## KITTITAS COUNTY FIRE MARSHAL'S OFFICE

Fire Marshal comments

Sage

RU-25-00003

SAGE CABIN STREAM BUFFER AVERAGING EXHIBIT

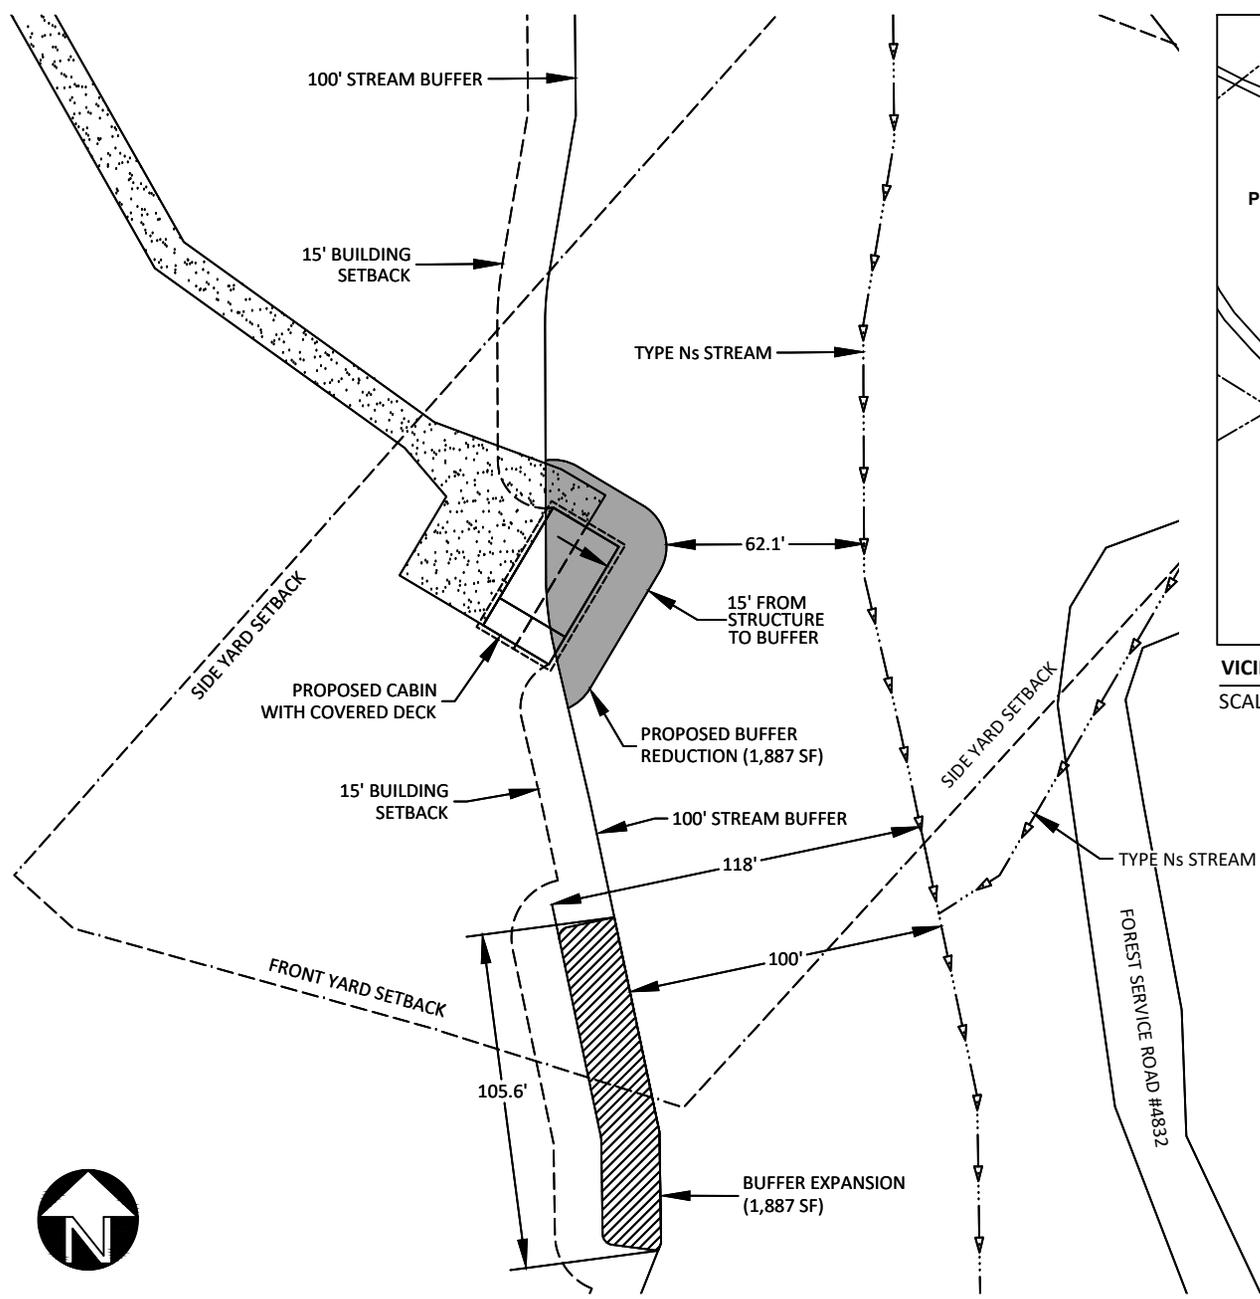
Approved fire apparatus turnarounds are required for this project. The indicated provisions for turning around fire apparatus are not adequate. Provide a turnaround meeting the requirements of the International Fire Code Appendix D.
